From: Nicola Spencer
Sent: 17 May 2018 18:03
To: Karen Parsons
Subject: FW: BR/41/18/PL EOT

From: Andrew Wood <Andrew.Wood@arun.gov.uk>
Sent: 30 April 2018 17:22:06
To: Hannah Seabrook
Subject: RE: BR/41/18/PL updated information

PROPOSED AREA ELEVATION PLAN

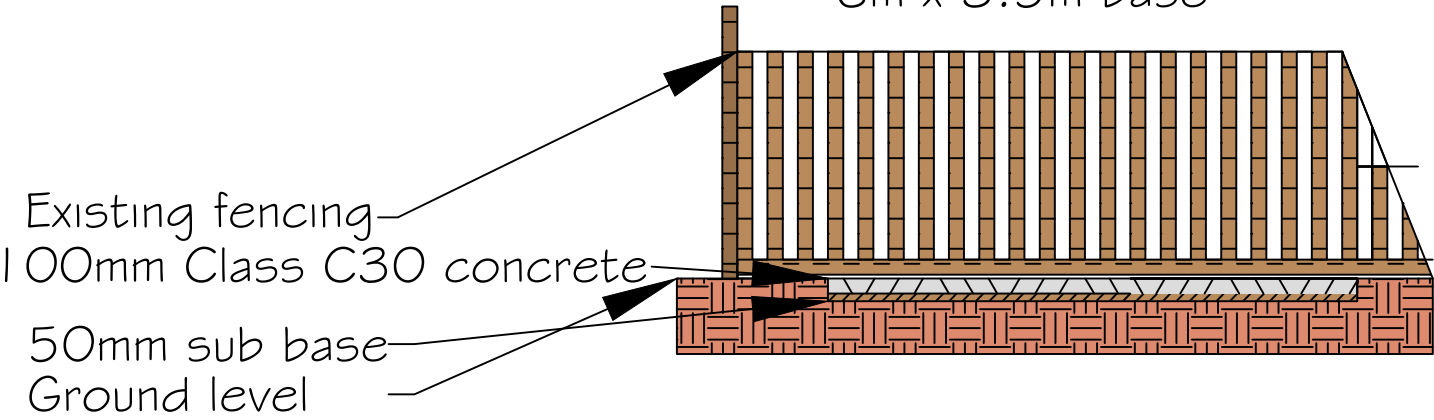
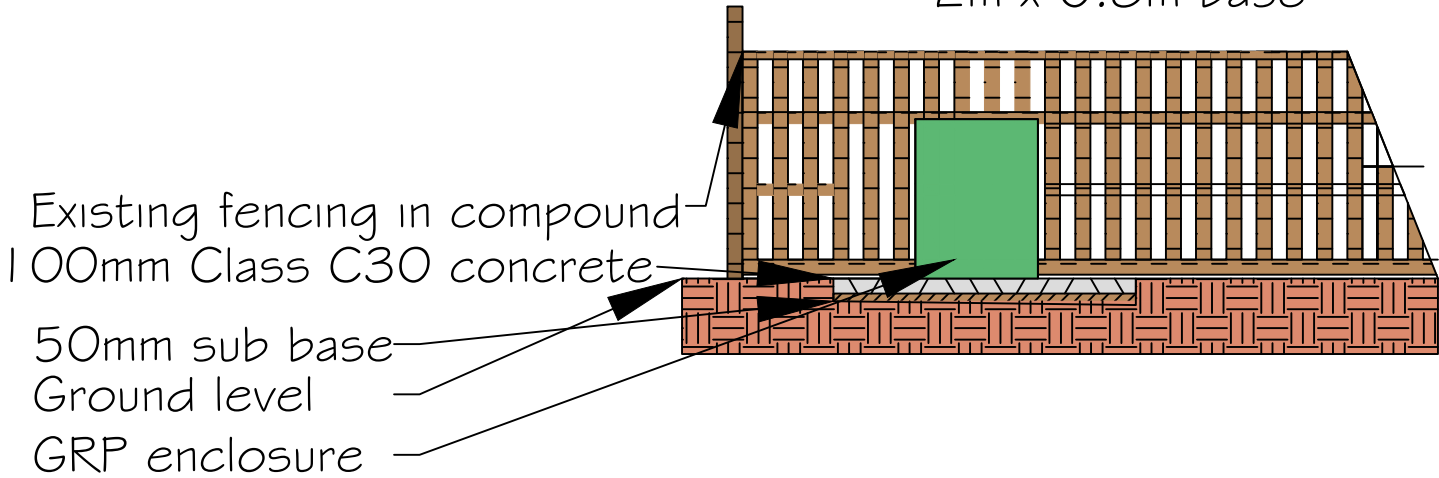
- 1) an elevational drawing of the new proposed 2.4 metres fence and gate around the 'proposed back up generator location on new concrete foundation pad'.
- 2) An elevation drawing of the new mini substation ideally showing both the sides and the end.

Those are already shown on the section drawings, and noted in the design and access statement.

I have updated the section drawing to make this clearer for you, and added a section line onto the site plan.
